Our reference: ECM 9126725
Contact: Gavin Cherry
Telephone: (02) 4732 8125

12 May 2020

Re: Response to Notification of Modification Application SSD 7173 MOD 8 – Altis Warehouse and Logistics Hub

JOB TITLE			Plan No.: 73535.014 VER 1
PLAN OF PROPOSED SUBDIVISION OF LOT 16 DP271141 ERSKINE PARK			
Reduction Ratio: 1: 3000	Date of Survey: N/A	Surveyor: GKO Drawn By: SF	Sheet 2 of 2

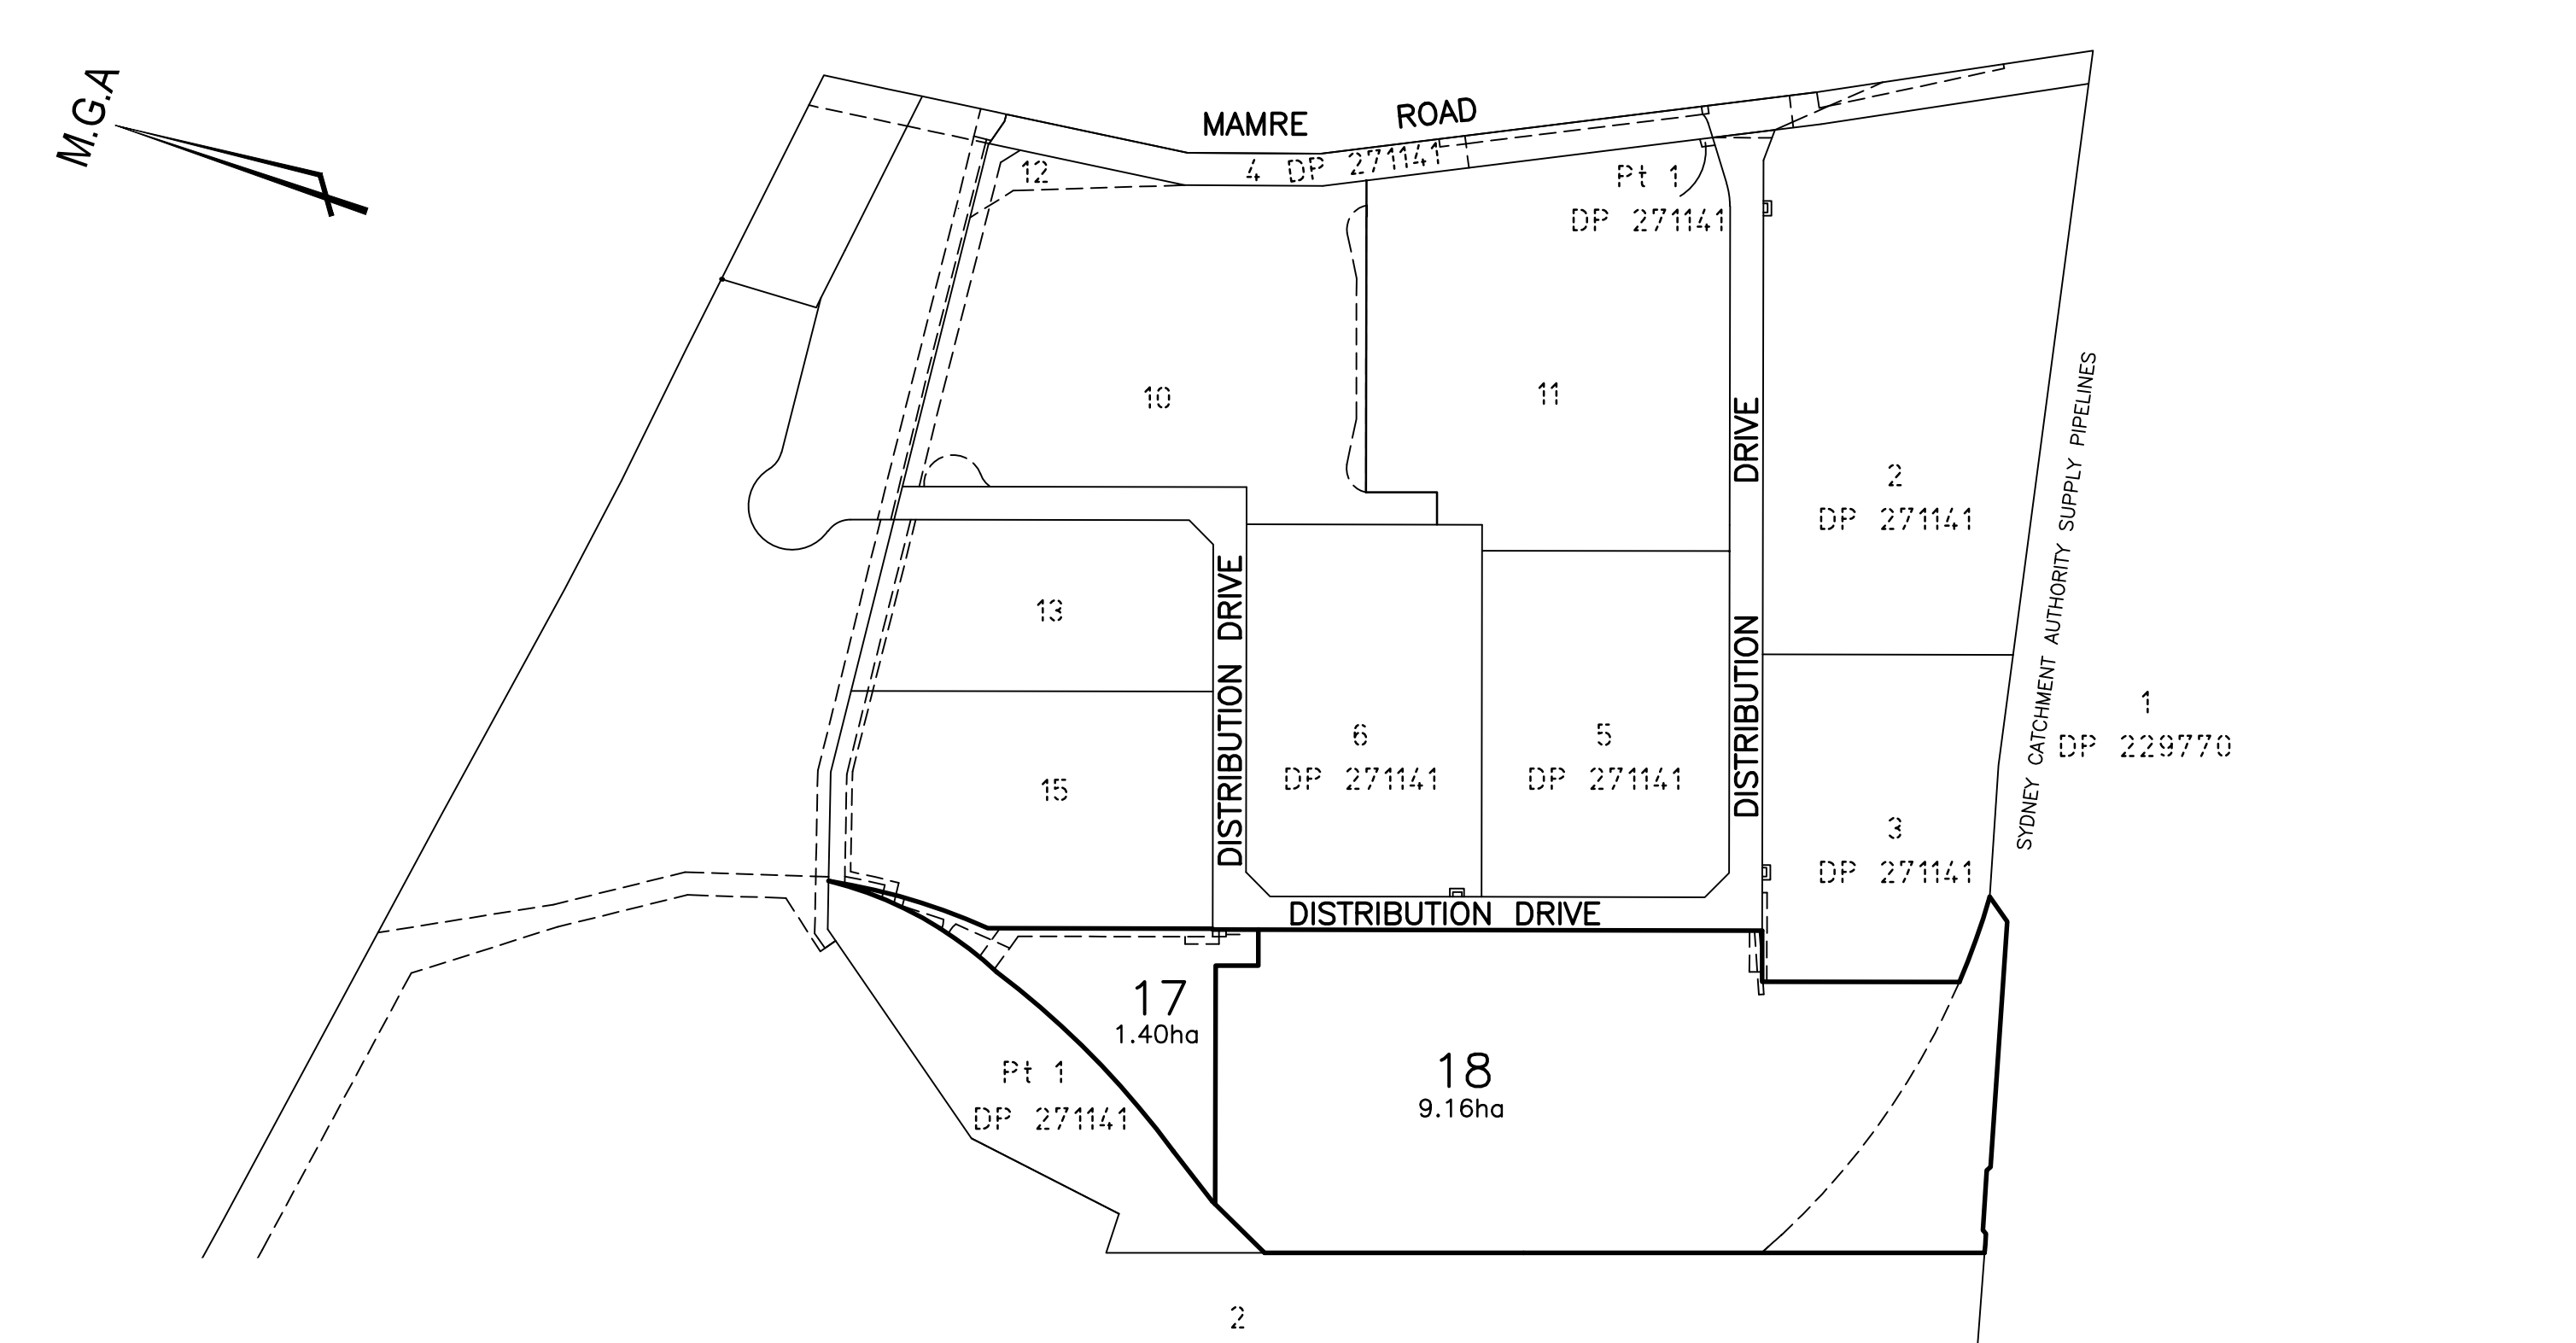
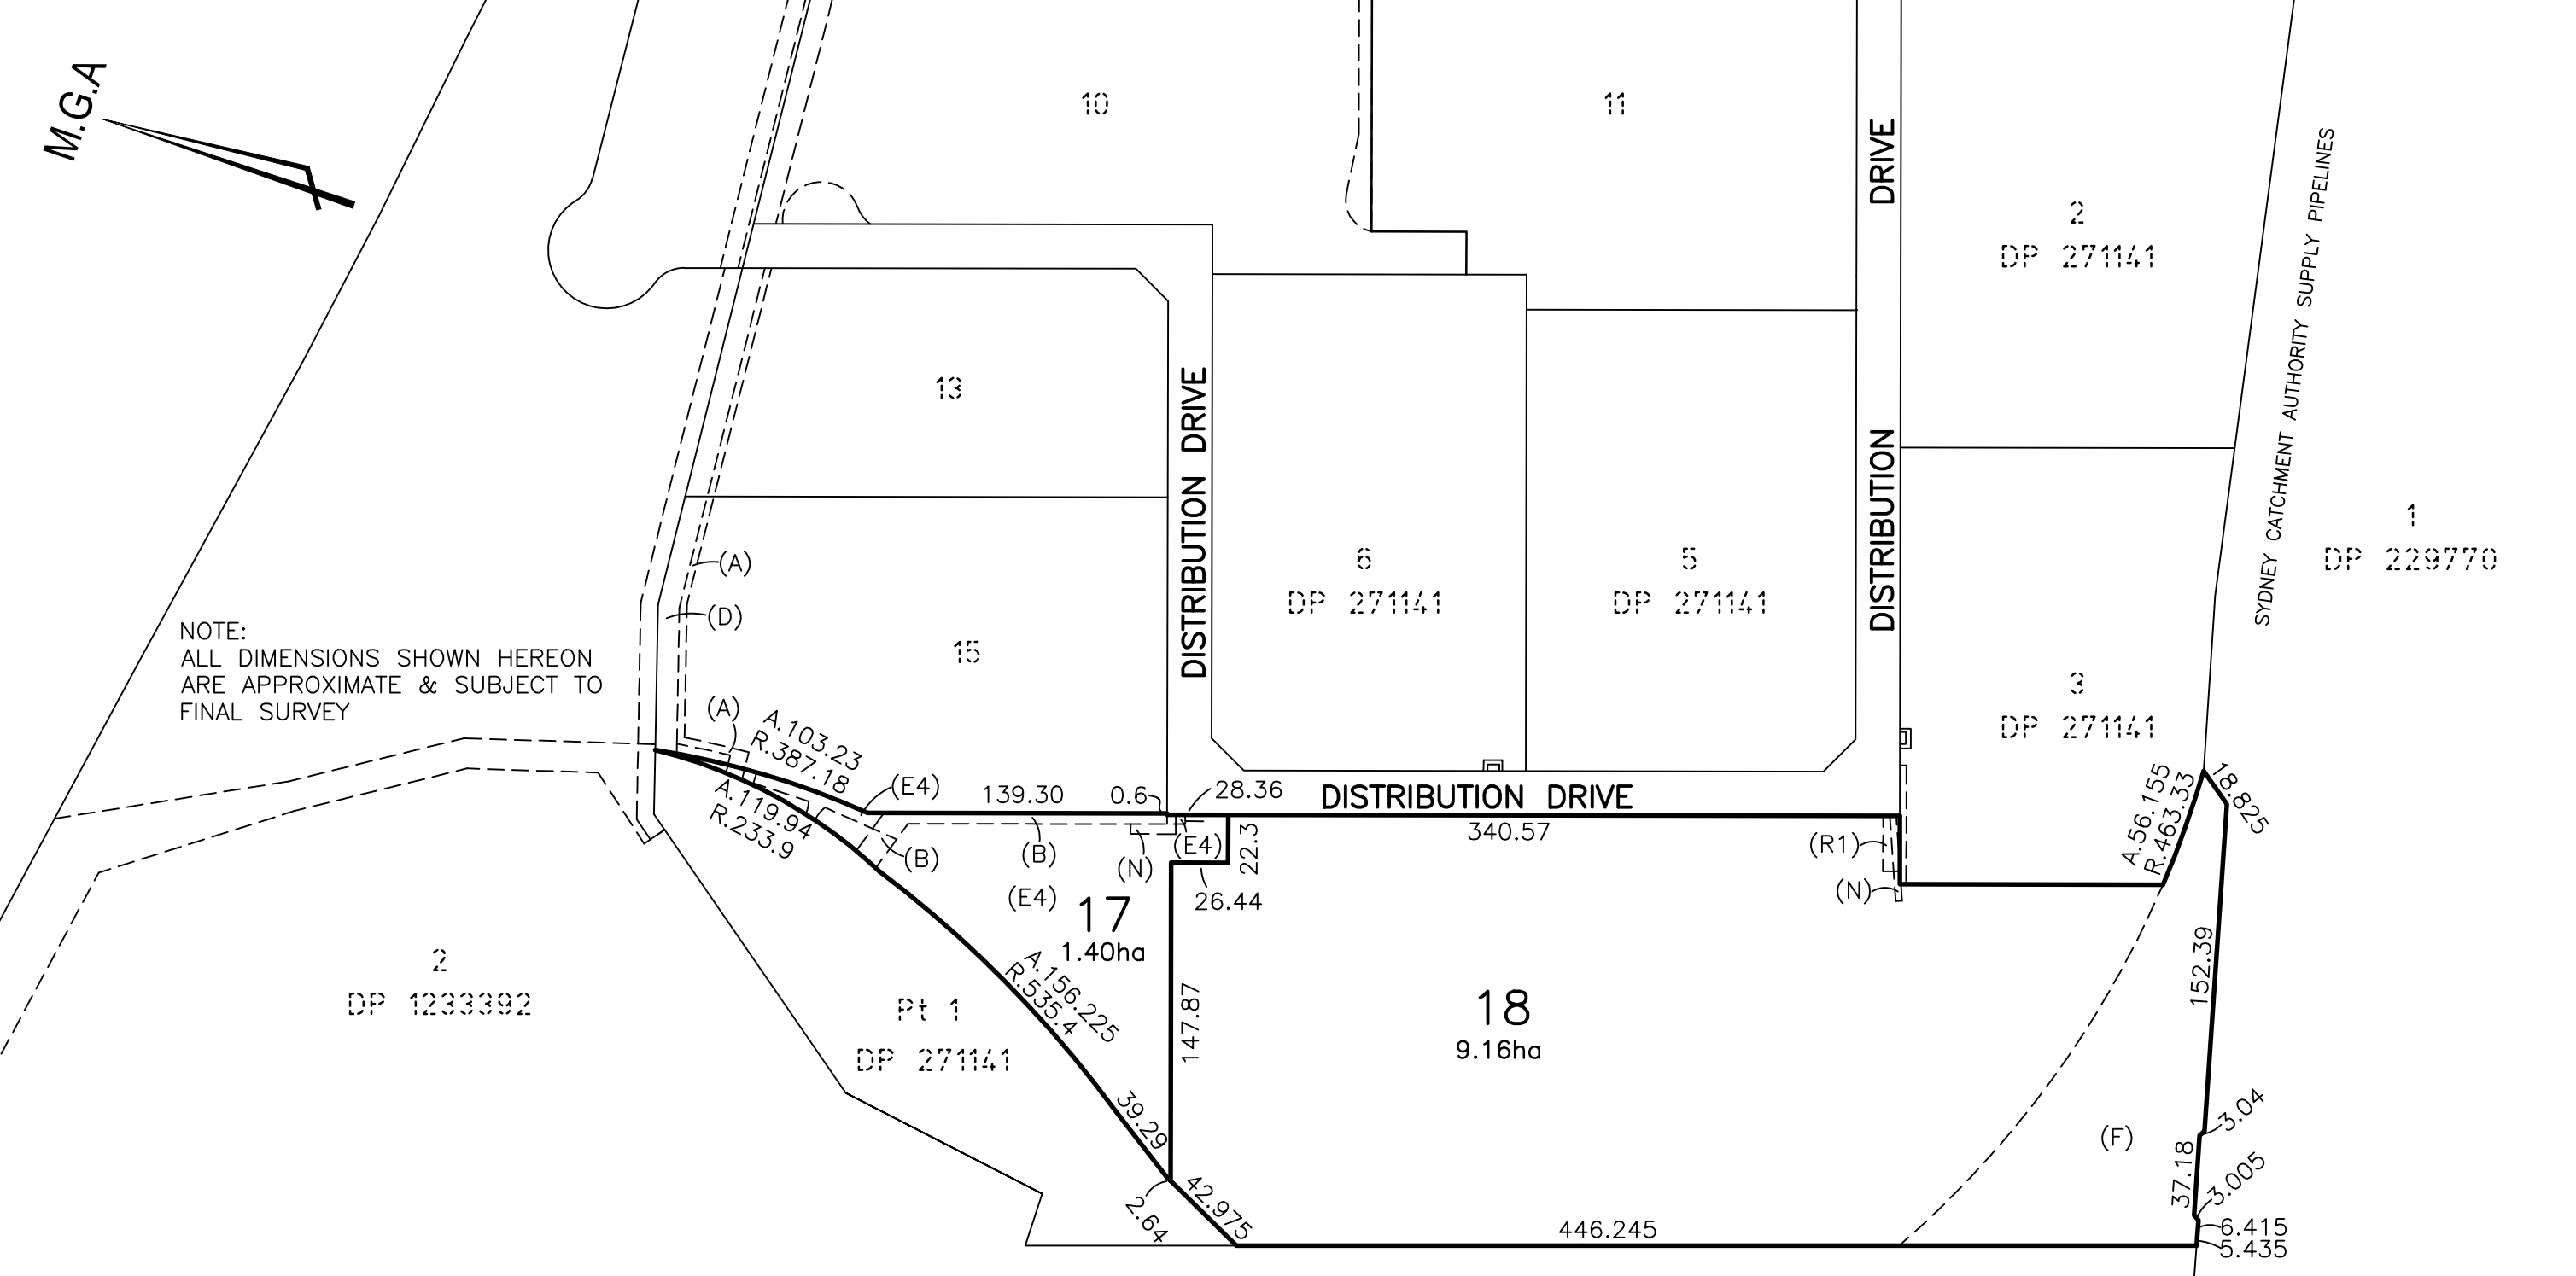
The indicated dividing boundary between Proposed Lot 17 and 18 is depicted within the SSD Mod 8 as a straight alignment. However, DA19/0897 as approved does not set up a straight regular boundary alignment and this is required to ensure clearances of the approved driveways to each development. Refer to the stamped approved plans attached to this letter.

The proposed plan of subdivision should be amended to reflect the allotment / lease boundaries established within DA19/0897, as the current boundary dissects the perimeter driveway for the built form on Proposed Lot 18 which is not appropriate. The proposed plan of subdivision and dividing boundary between Proposed Lot 17 and Lot 18 must be consistent with the boundaries established within DA19/0897 and clear of works approved. The stamped approved Site Plan best reflects the required boundary dimensions and allotment shape for Proposed Lots 17 and 18.

In addition, if the proposed amended subdivision occurs and divides existing Lot 16, then the registration of a drainage easement through proposed Lot 17 to the benefit of Proposed Lot 18 will need to be established and conditioned accordingly.
